**West Yorkshire Police  
Kirklees District**

**Designing Out Crime Officer**

To: Nia Thomas Kirklees Council Planning Services Civic Centre 1, High Street, Huddersfield, HD1 2NF	Ref: 2020/92351 Date: 3 <sup>rd</sup> September 2020
---	---

**Site Location: Former Batley Police Station, Market Square, Batley, WF17 5AA  
Application for: 9 No. Self-contained flats**

Scale: As Shown @ A1	Drawing No. 3078/03
Date: MAY 2020	
Drawn by: SS

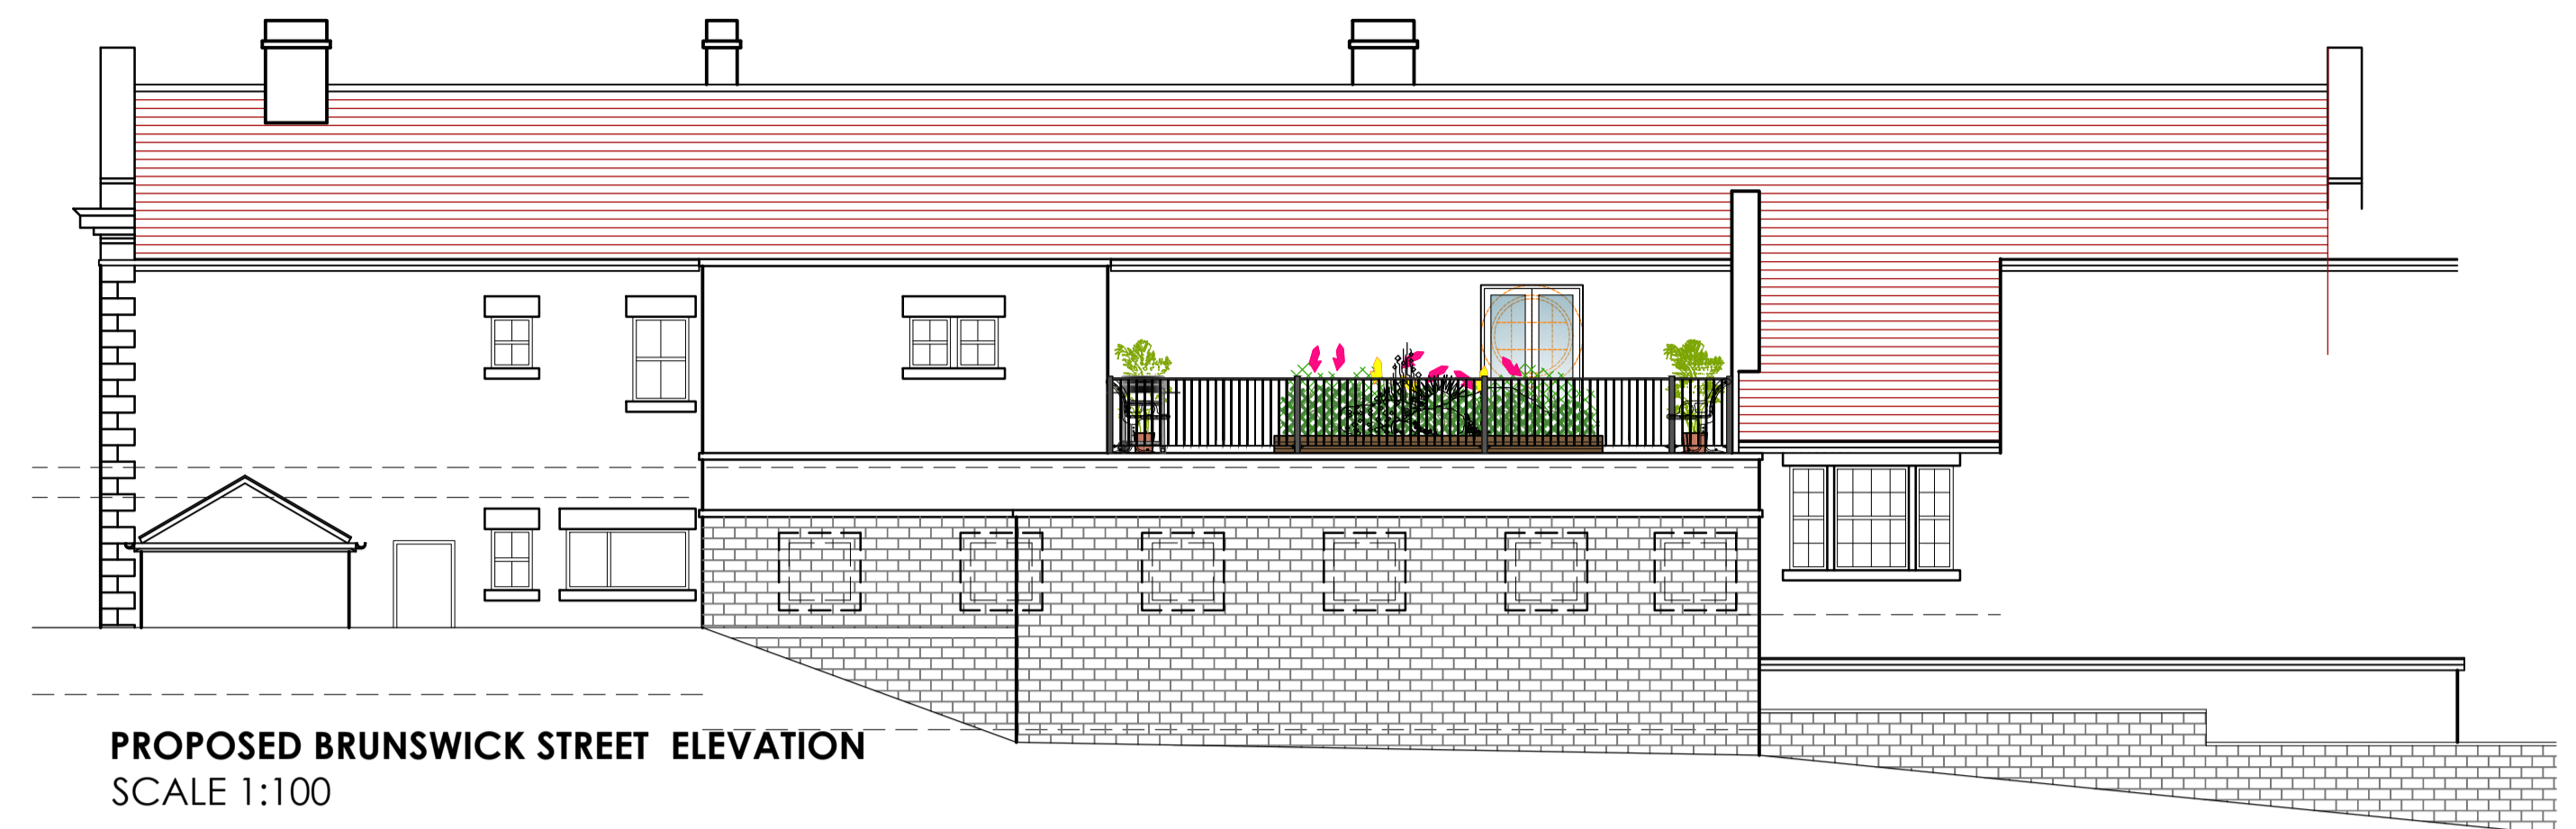
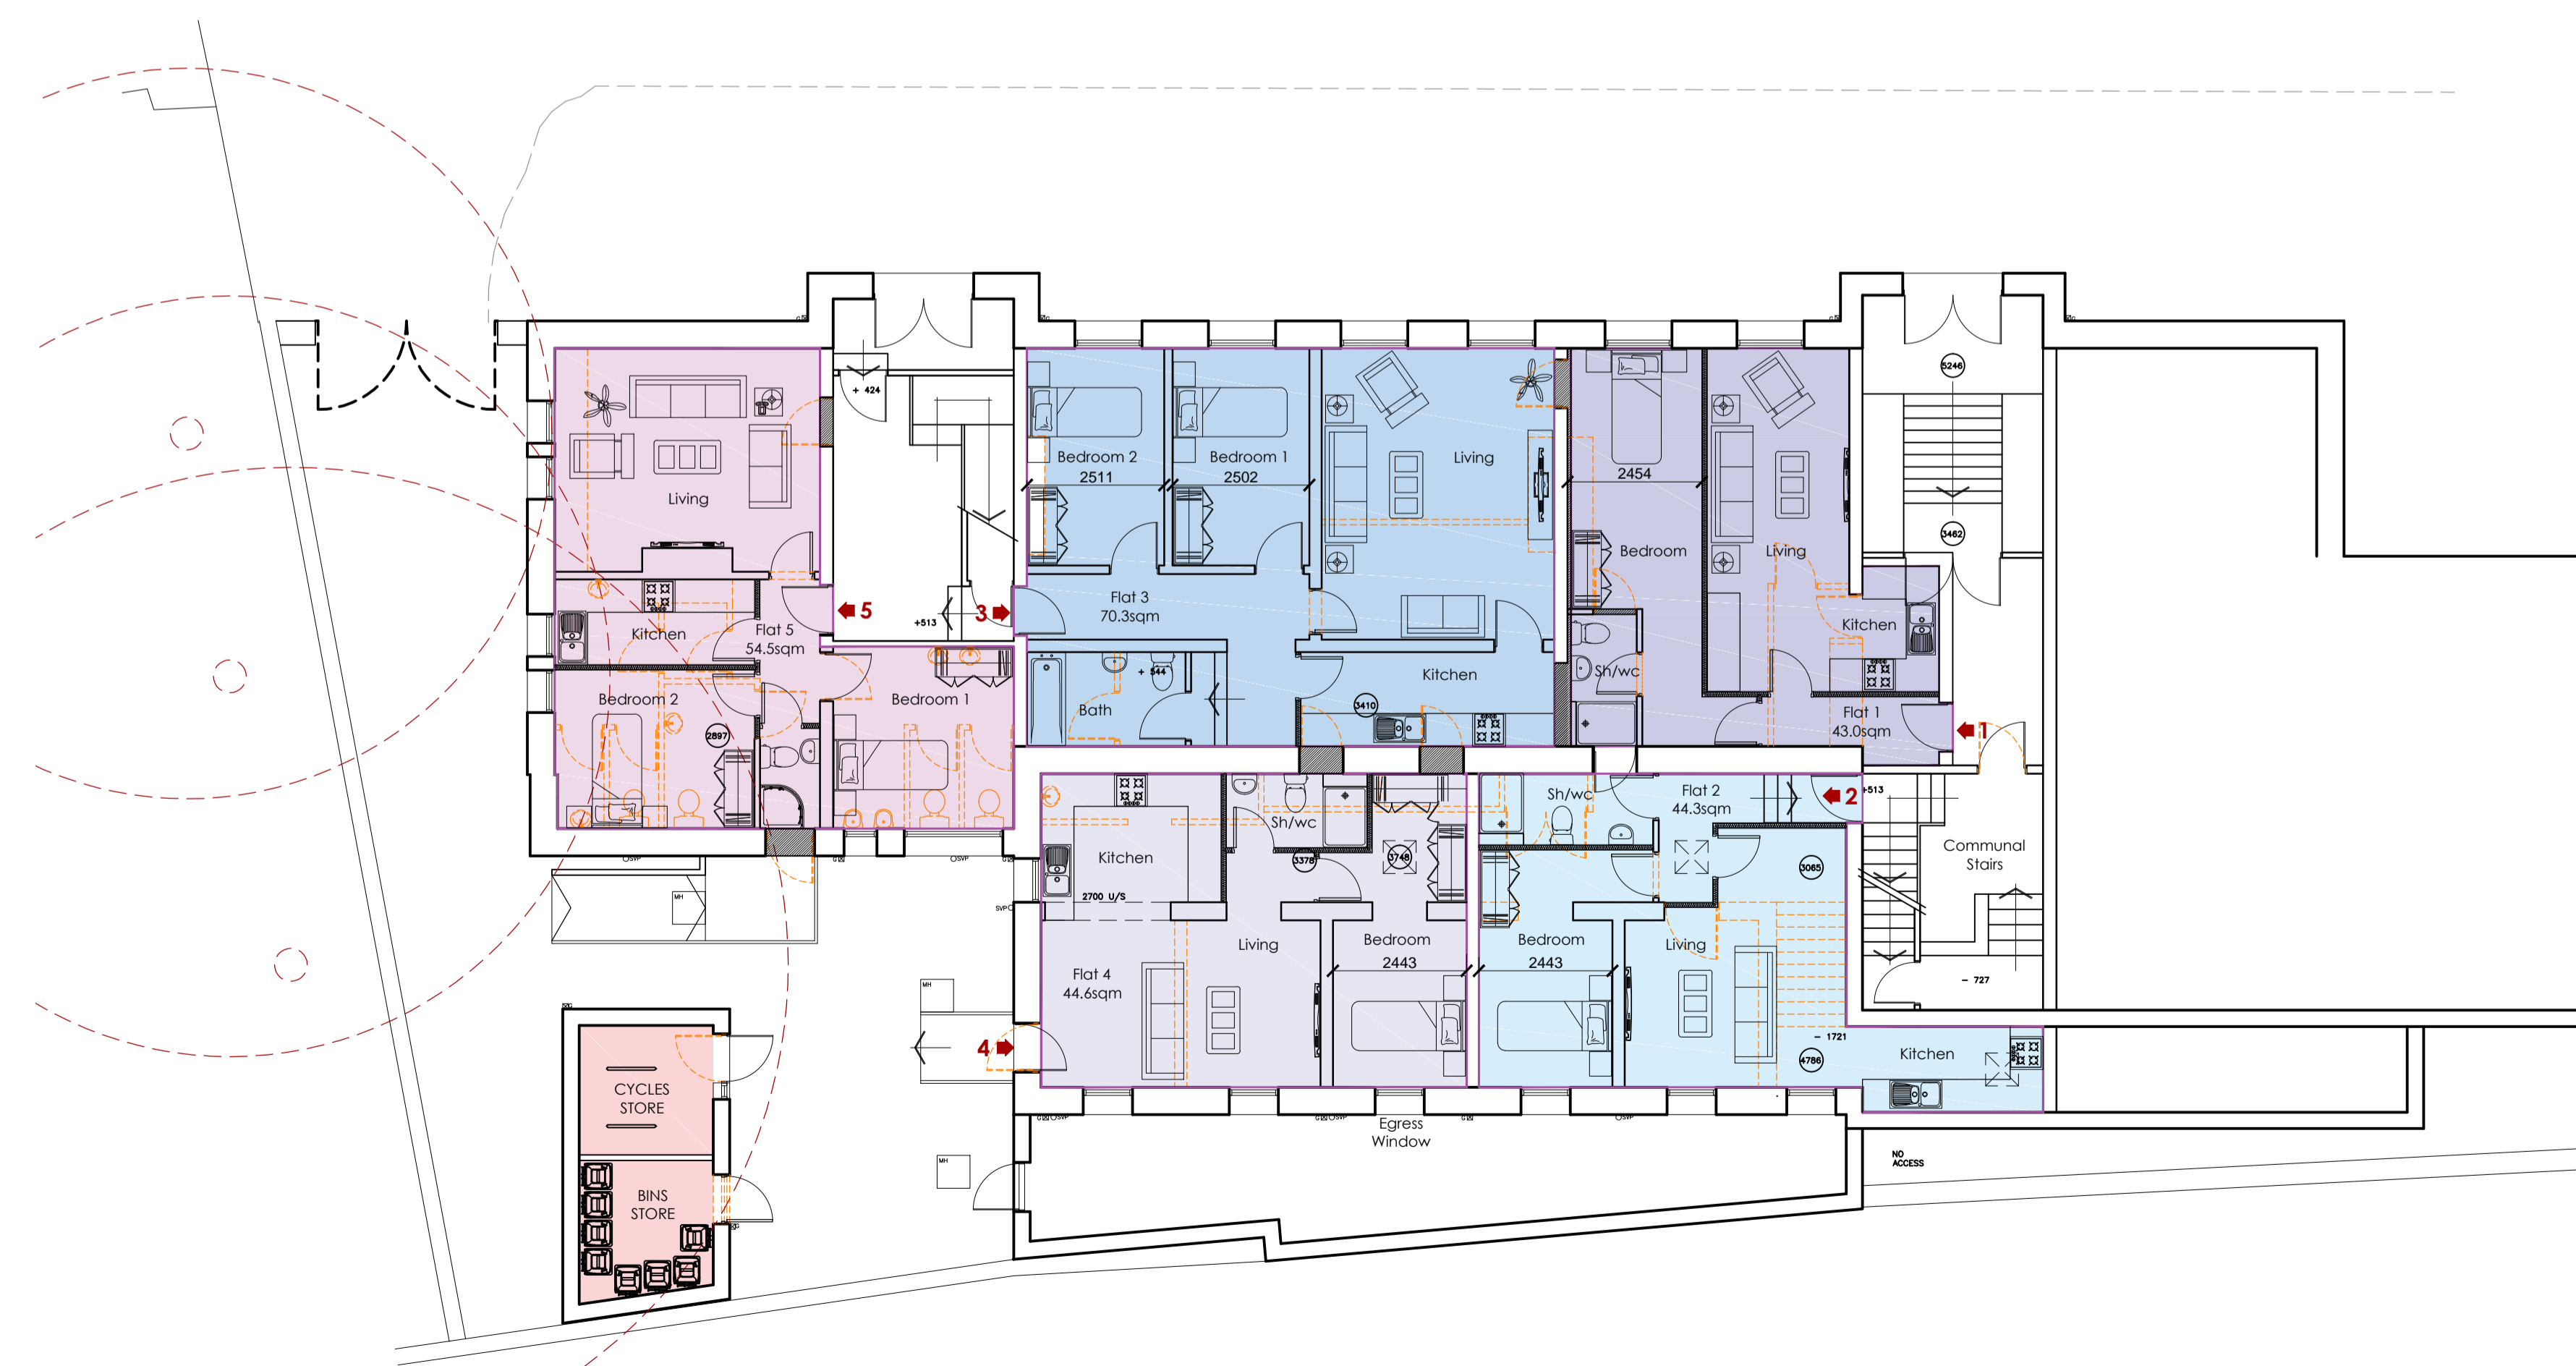
Referring to site plan drawing number 3078/03 dated May 2020.

- Gates to the front elevation must be access controlled to prevent unauthorised entry into the rear yard of the property.
- The main entrance doors at the front must also be fitted with access controlled locking and door video intercom systems linked to each of the flats.
- The cycle and bin store doors require security access controlled locks.
- Climbing access must be prevented to the rear upper terracing by making this area inaccessible from the yard.
- The shown doors into each flat and those that emerge onto the communal terrace must be to PAS24:2016 or LPS1175 Issue 7 BR2+ standards with locks to TS007 3\* or above as advised below.
